**From:** Jamie Turlington  
**Sent:** Monday, March 20, 2023 12:02 PM  
**To:** kwaldrep@algsenior.com  
**Cc:** Donna Johnson  
**Subject:** The Springs of Ballentine, 40 Rawls Rd Sanford NC 27331/BCOM2302-0007

Thank you for taking the time to speak with me last week regarding the review of The Springs of Ballentine. This is a follow up email to summarize some of the items discussed and what I need to move forward with the plan review. Our plans show Revision 01 and are dated January 20, 2023. I believe you told me you have plans that show Revision 2 and are dated March 3, 2023. Please submit the most recent set of plans. Any changes to the plans, such as adding handsinks, will require submittal of plans with the changes. Please forward the plans and information requested to Central Permitting. Building will need to see the revised plans as well.

**A201**  
 OVERALL FLOOR PLAN

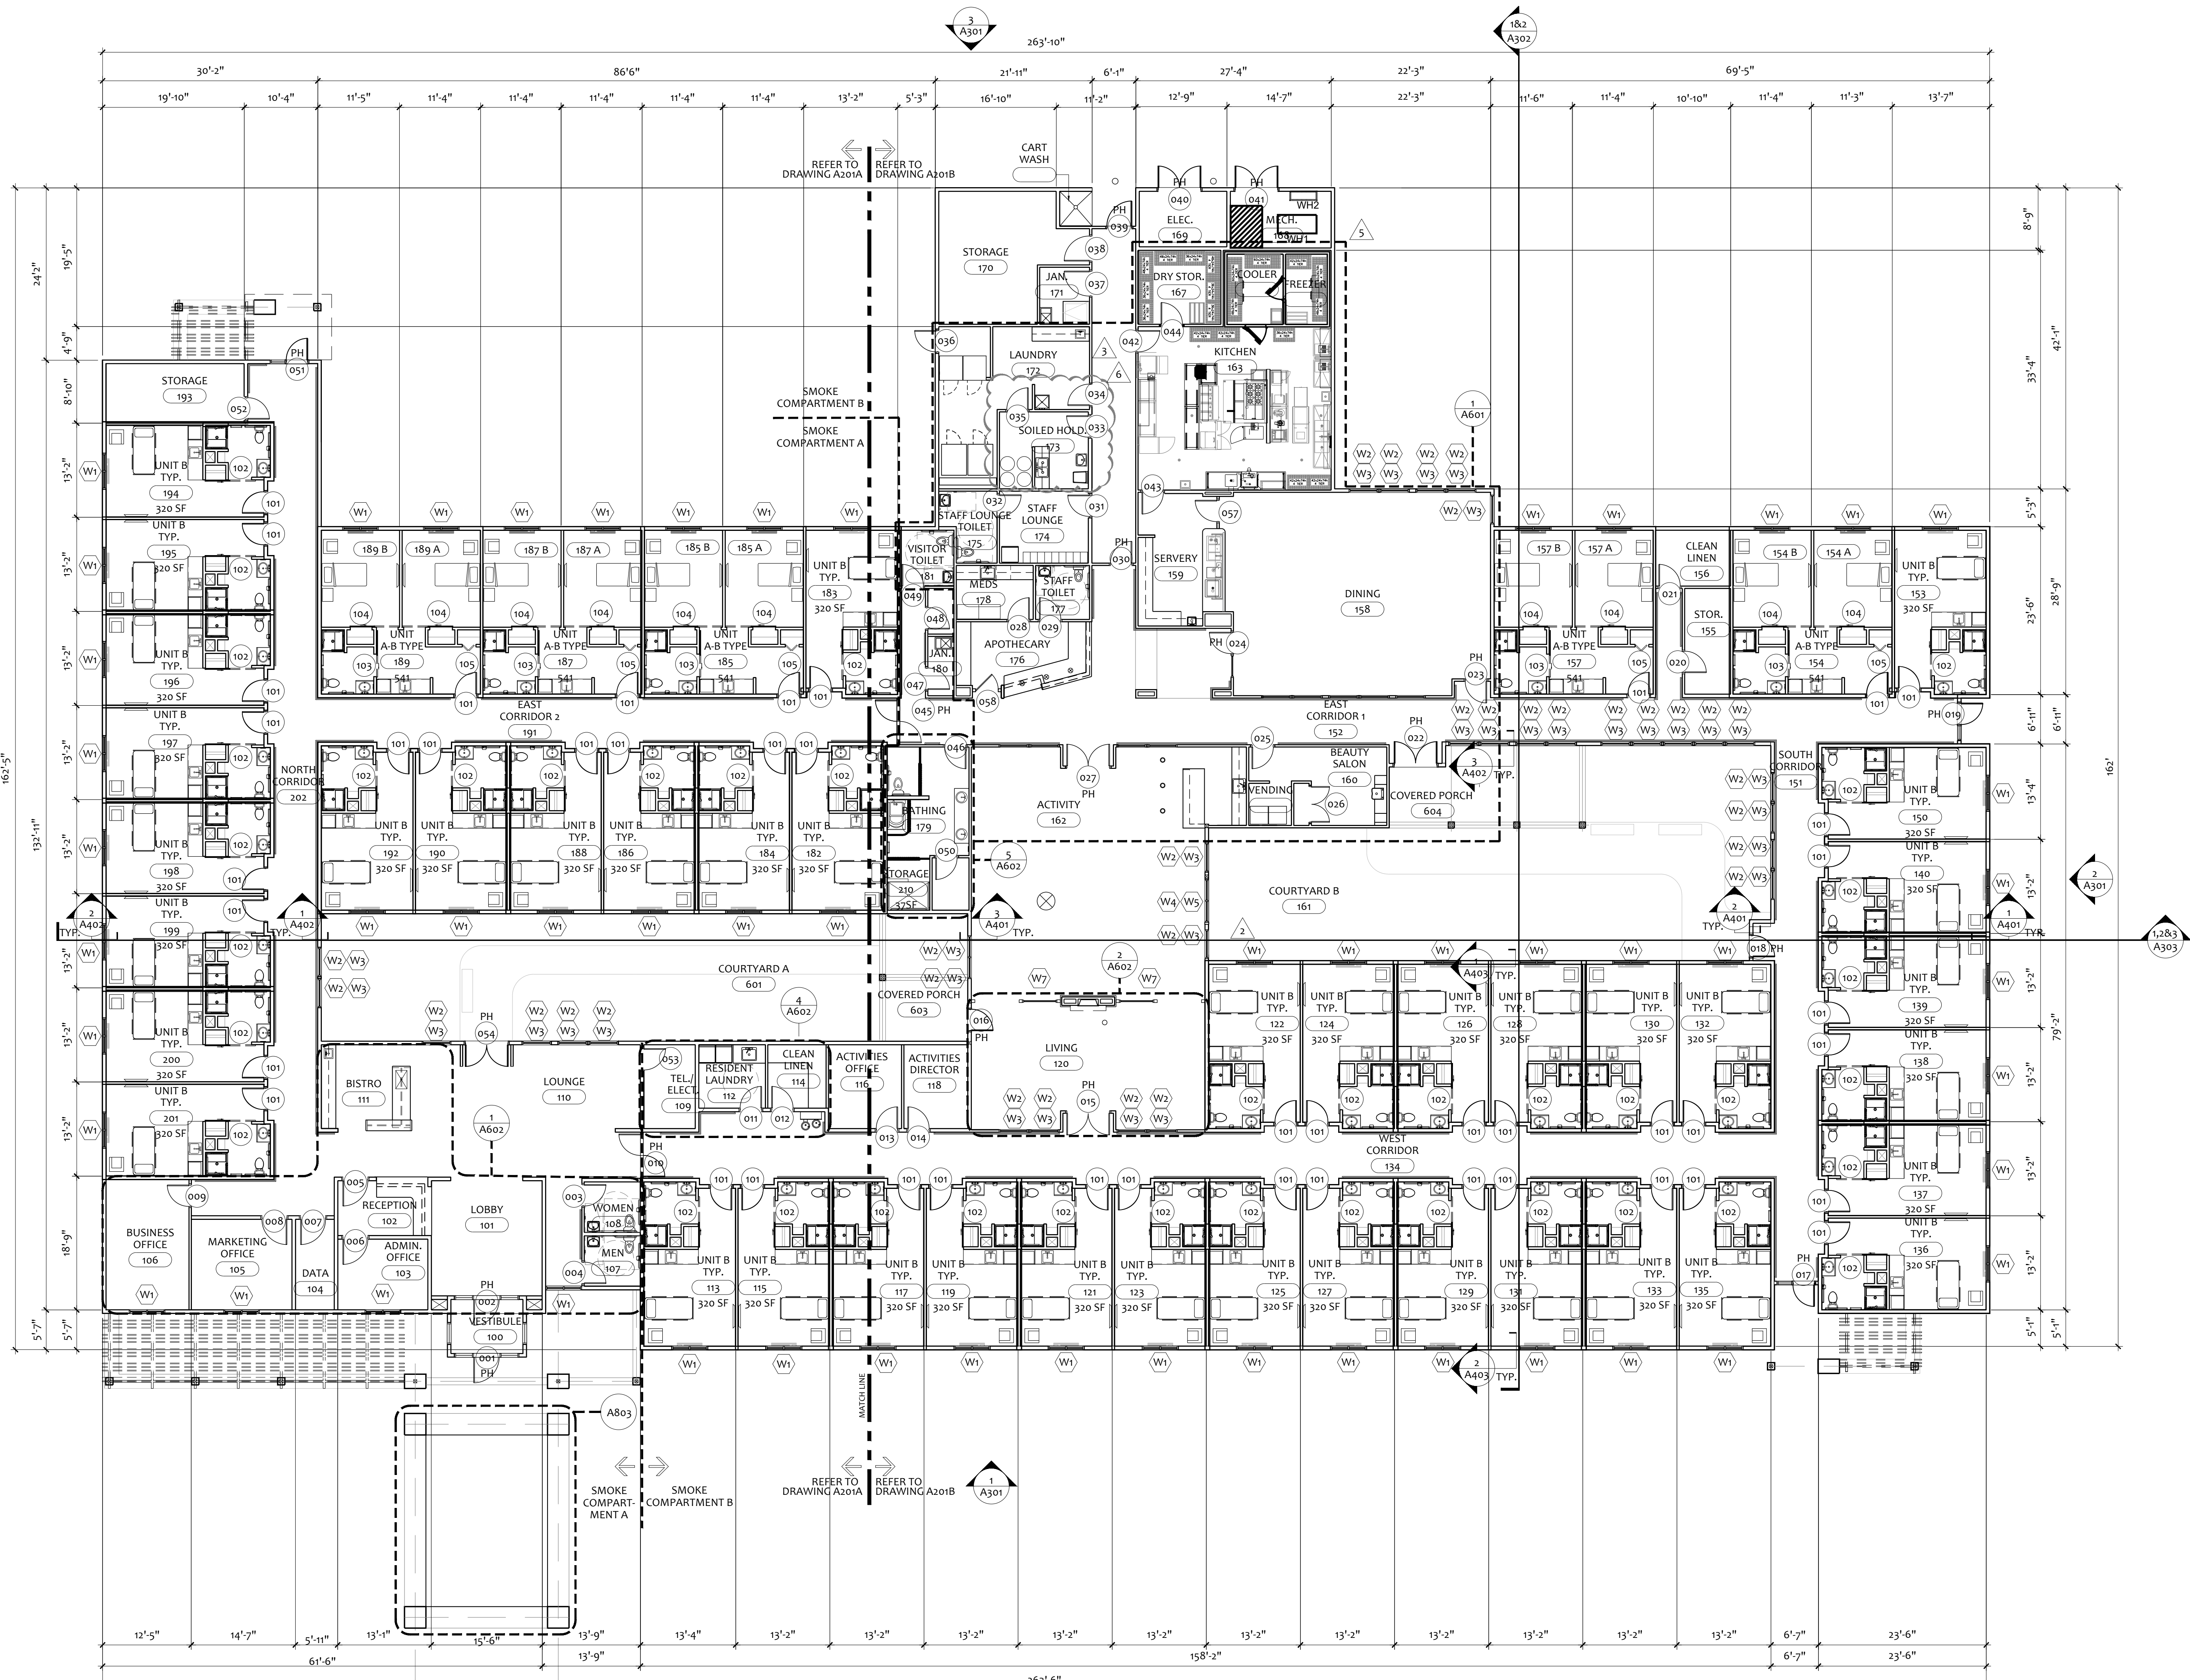
5. Plans do not show a handsink in the bistro area where plated food will be handed out, as described. Provide a handsink in the bistro area. **To be provided on revised plan**

**1 LAUNDRY/CARE BASE/MEDS/SERVERY/STAFF LOUNGE & BEAUTY**  
1/4" = 1'-0"

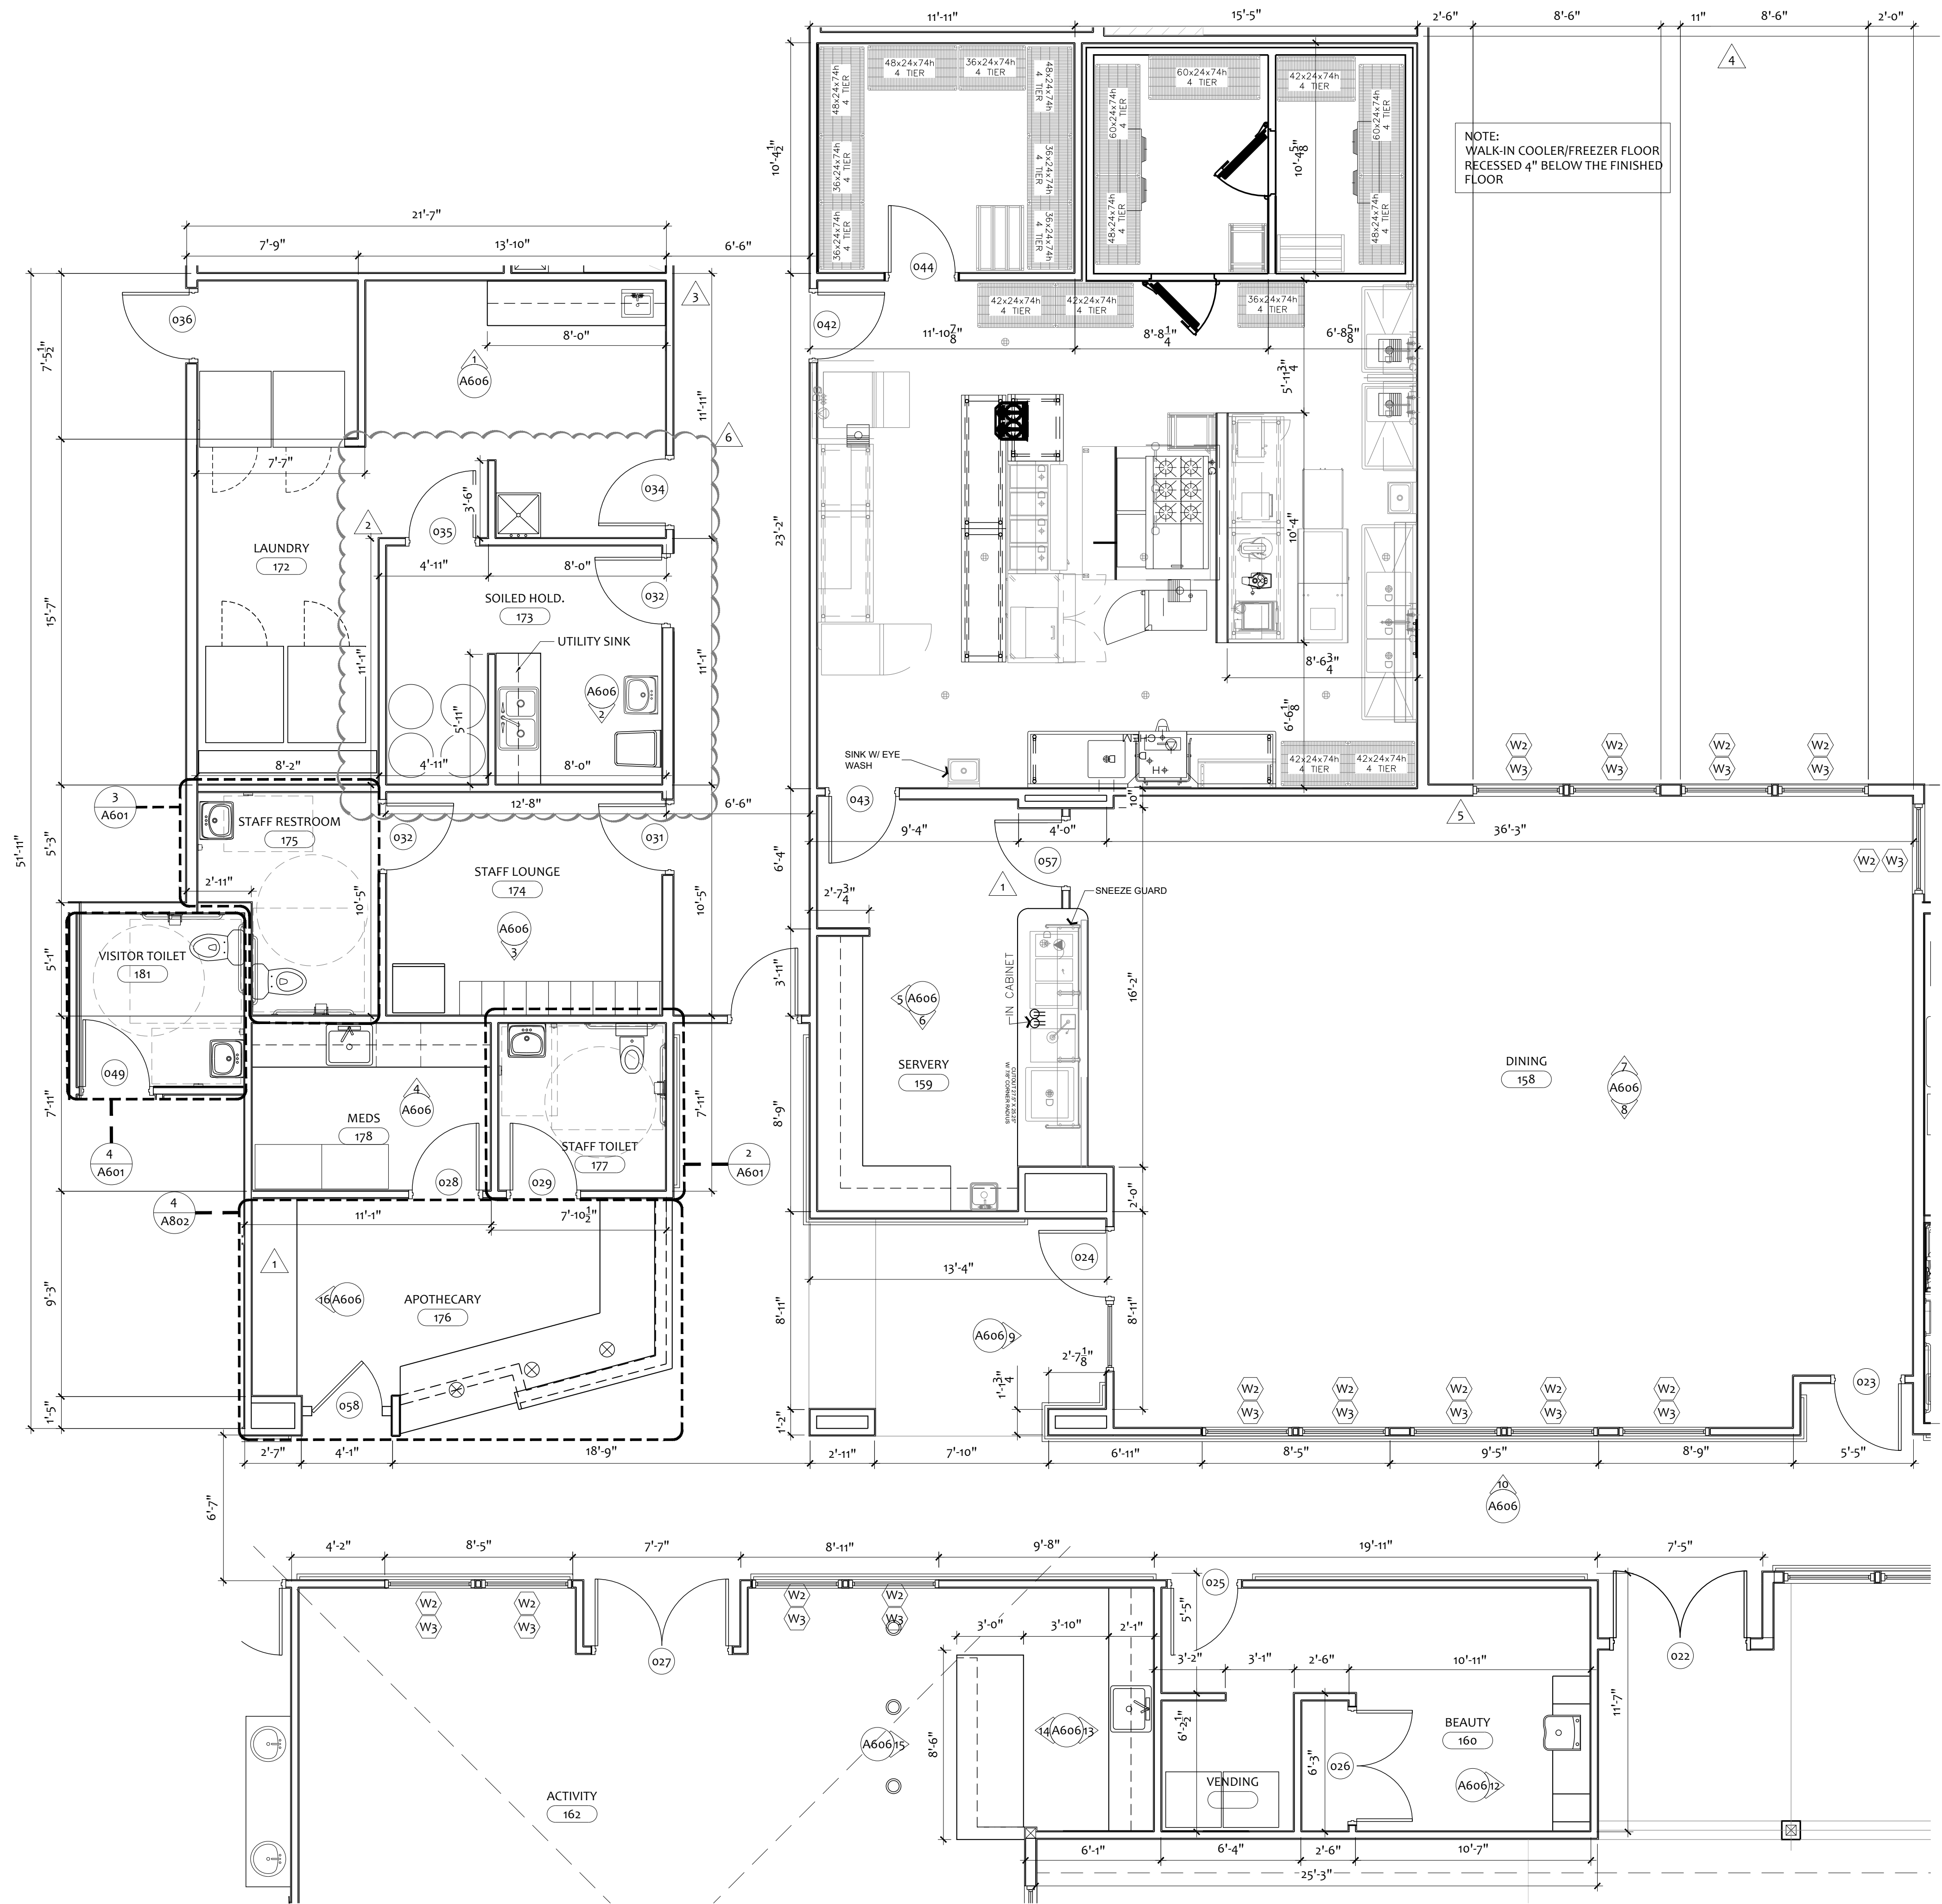
1. Provide a site plan of the laundry areas and label the equipment on the site plan. Provide a corresponding equipment specification sheet for the equipment in these areas. **To be provided**

4. Indicate the intended use of the sink in the clean linen area of the laundry room. Additional handsink to be added to the laundry area #172 on the plans as discussed. **To be provided on revised plan**
